CITY OF MERCER ISLAND

RE: Request for Information - File Nos. SEP16-015/ZTR16-002
Mercer Island Center for the Arts
3205 77th Avenue SE
Mercer Island, WA 98040;
King County Tax Parcel # 1224049068

MERCER ISLAND CENTER FOR THE ARTS CONCEPTUAL MITIGATION PLAN

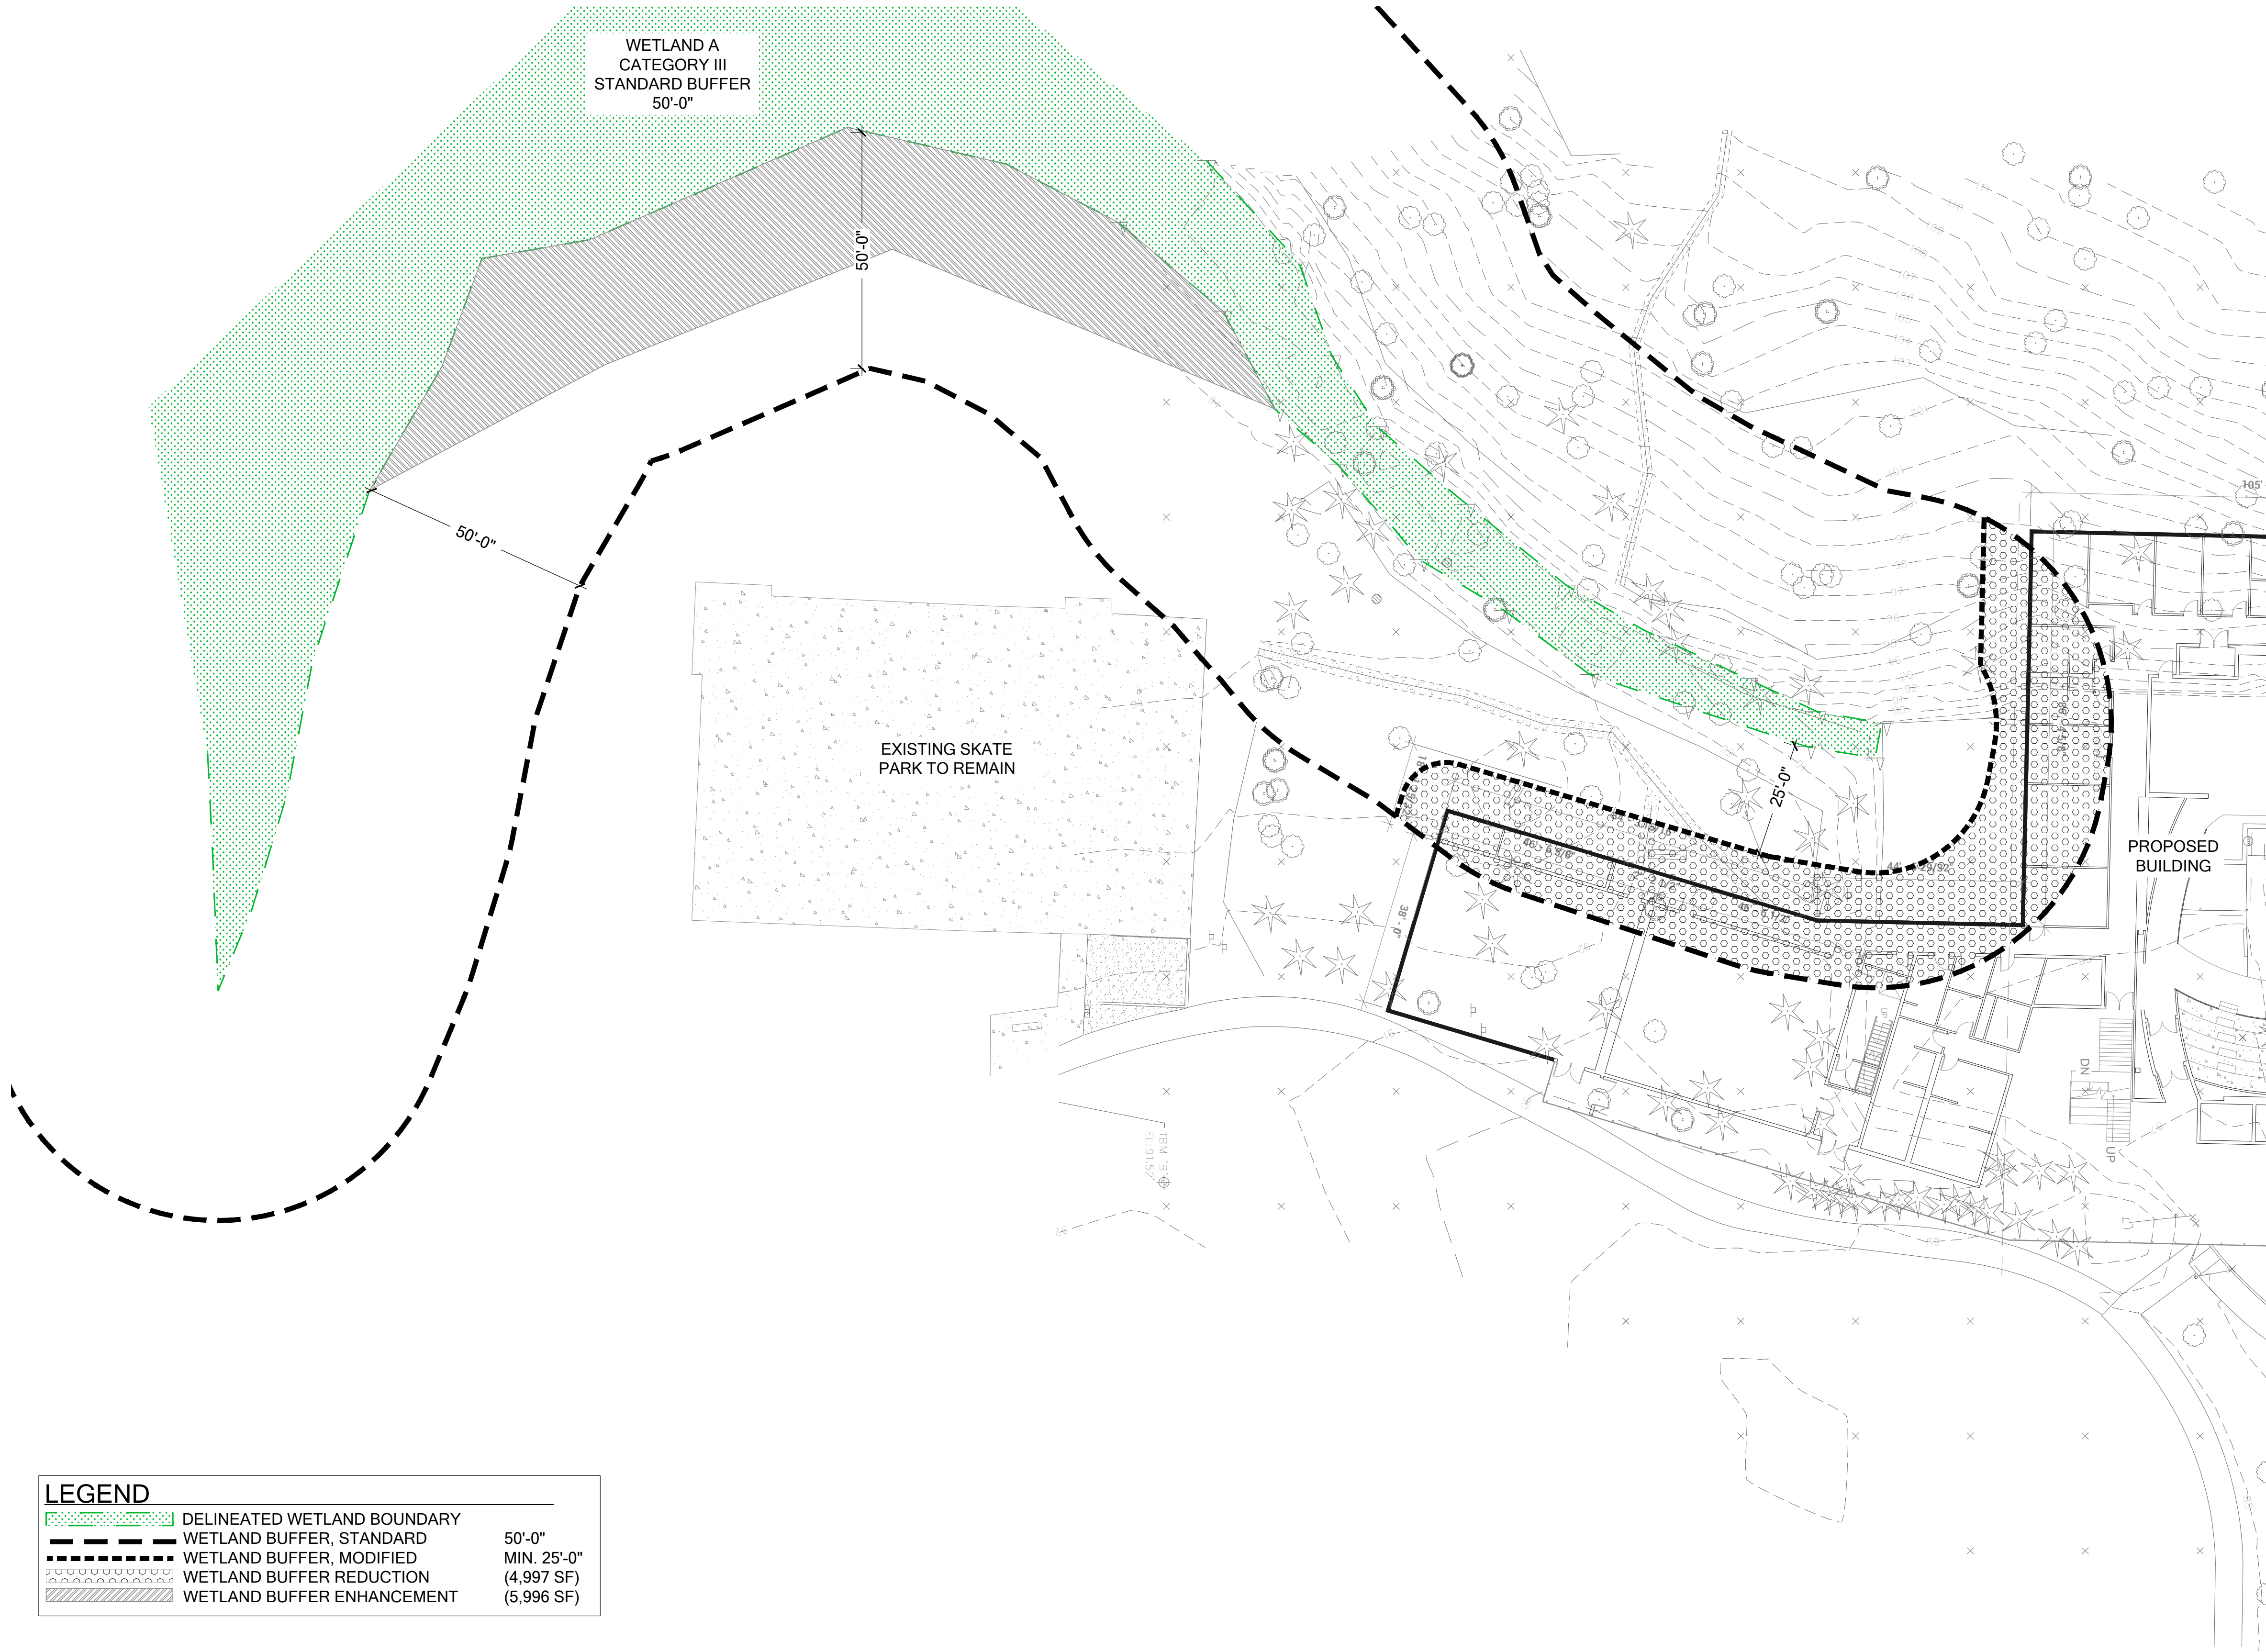
5. Attachments C and D (geotechnical information) need to be updated or supplemented to reflect the currently proposed plans.
6. Attachment F (wetland mitigation proposal) needs to be updated or supplemented to reflect the currently proposed plans and proposed mitigation.

1 SHORT PLAT
1" = 50'-0"

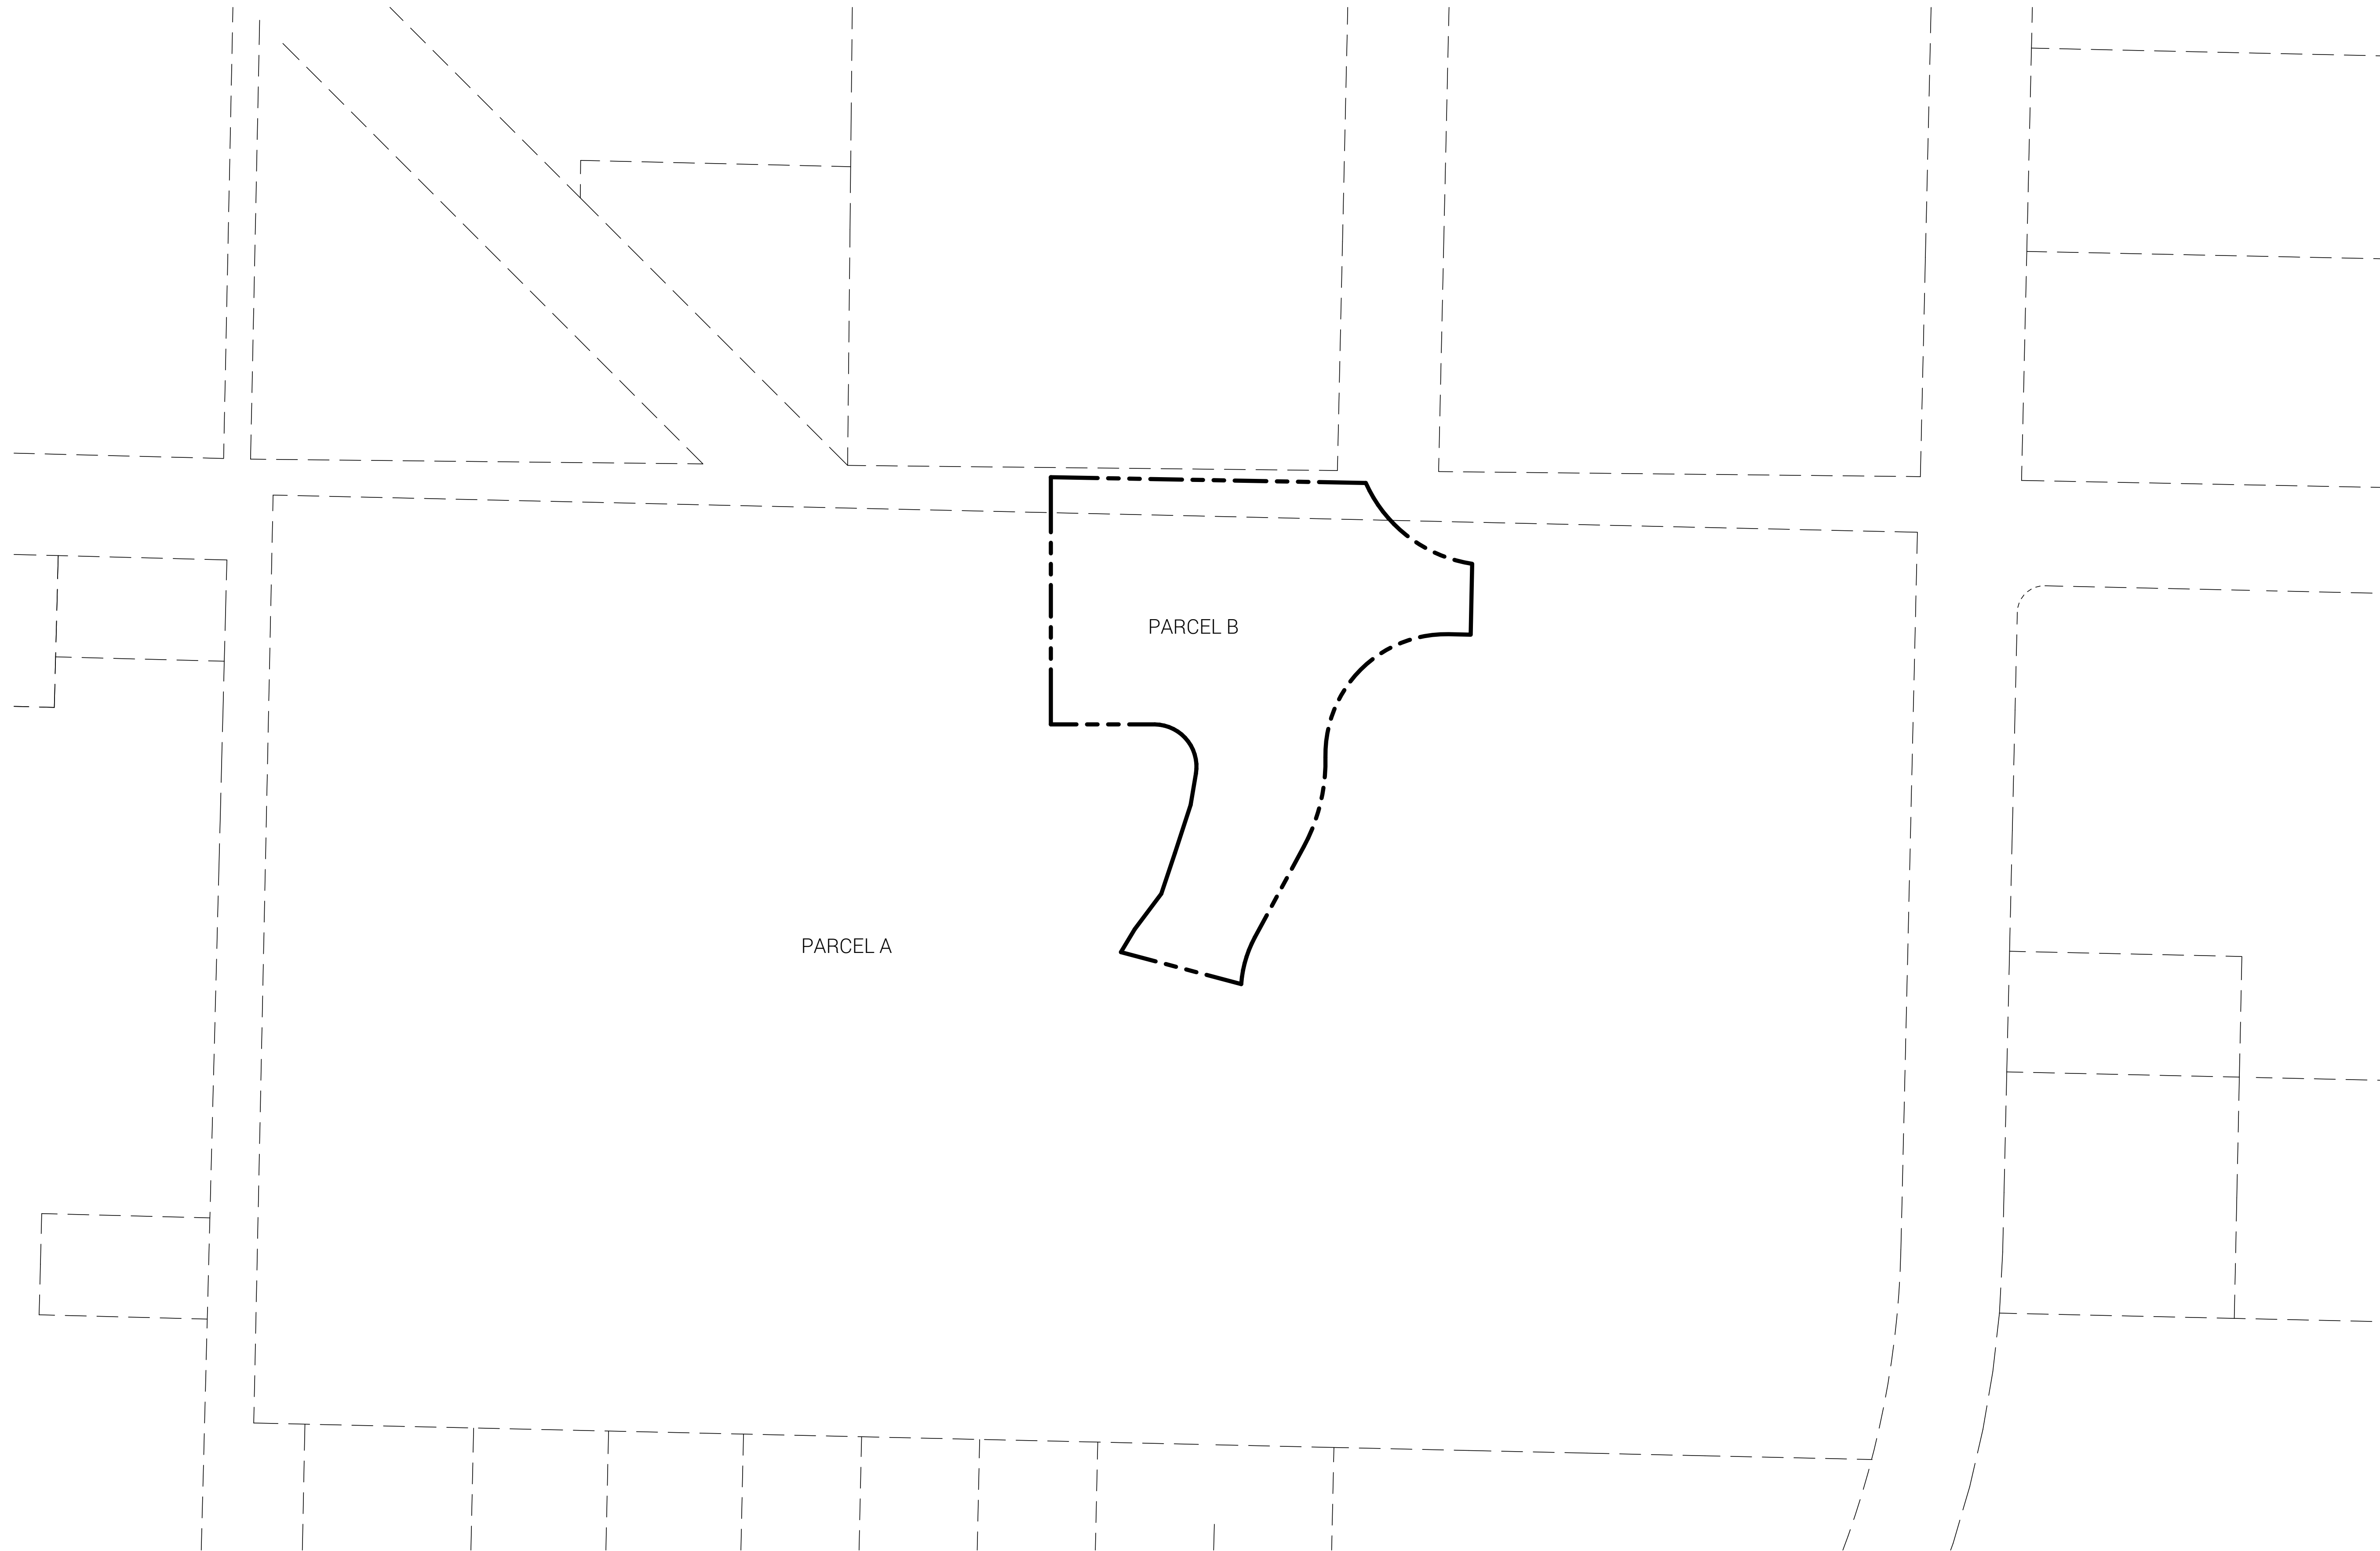
1. MICC 19.16.010 defines "subdivision" as: *"The division or platting of, or the act of division or platting of, land into two or more lots for the purpose of transfer of ownership, building development, or **lease**, whether immediate or future, and shall include all resubdivision of land."* (emphasis added) Please modify the submitted SEPA Checklist to include a short subdivision (short plat) as part of the project.
2. MICC 19.09.090 requires designation of a building pad for each lot in a short plat. The designated building pads need to be shown as part of the supporting materials for the SEPA Checklist to allow evaluation of any environmental impacts. Please submit supporting information showing how the proposed building pads comply with MICC 19.09.090:
